**Application for Approval of Details Reserved by Condition
Town and Country Planning Act 1990
Planning (Listed Buildings and Conservation Areas) Act 1990**

Discharge of conditions 6 (right-turn lane), 8 (Construction Management Plan), 10 (electric vehicle charging), 11 (Phase II report), 16 (Air Quality Impact Assessment), 18 (temporary drainage), 20 (surface water drainage), 22 (hardstanding drainage) and 27 (external lighting) of previous outline permission 2019/92221 for demolition of existing buildings and erection of Class E retail unit, access, car parking, servicing, landscaping and associated works (all matters reserved other than access)

119, Huddersfield Road, Mirfield, WF14 9DA

Application Number: 2023/92061

Project:		HUDDERSFIELD ROAD MIRFIELD	
Client:		ALDI STORES LTD	
Drawing:		SECTION 278 WORKS GENERAL ARRANGEMENT	
Drawn By:	TS	DATE:	05/05/2022
Checked:	RC	Scale:	1:250 @ A1
Drawing No:	AMA/40110/D/001	Rev:	1

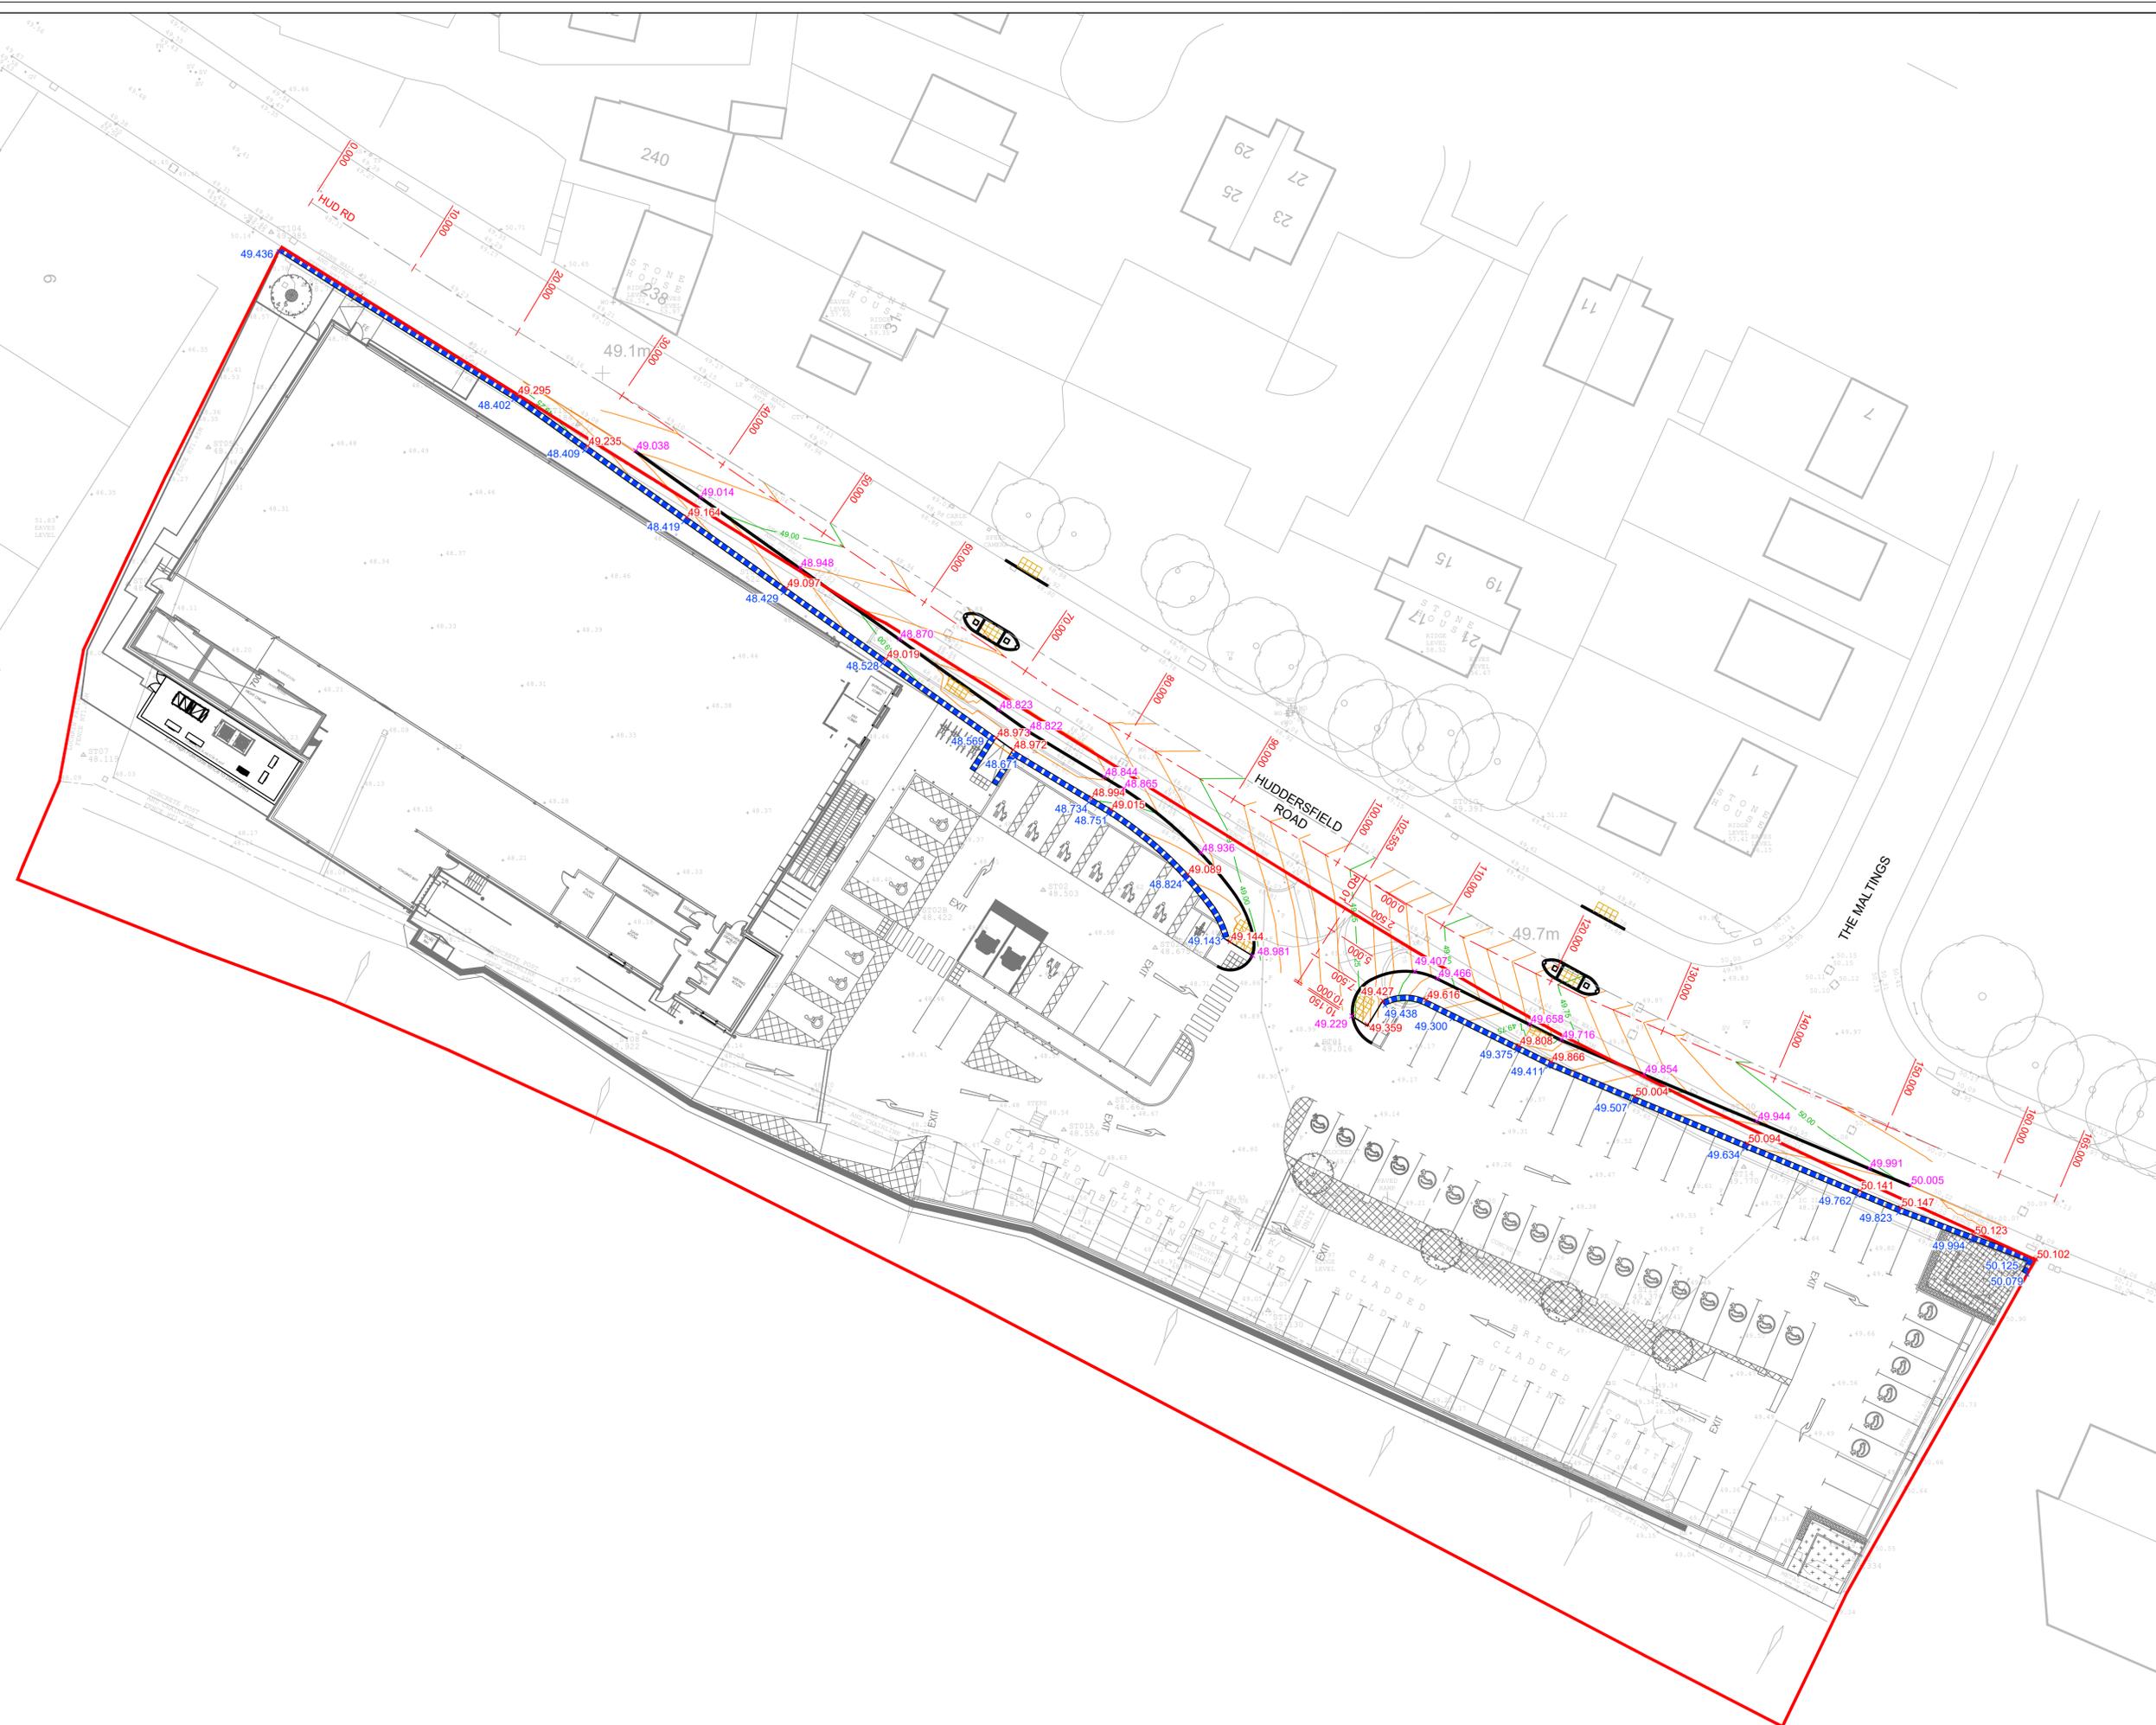
The submitted details are not accepted. It is understood that negotiations are continuing between your team and K.C. Highways (Section 278 team), with various concerns raised and outstanding. The current proposal would not secure the safe and effective use of the highway. Negotiations should continue to resolve any outstanding matters.
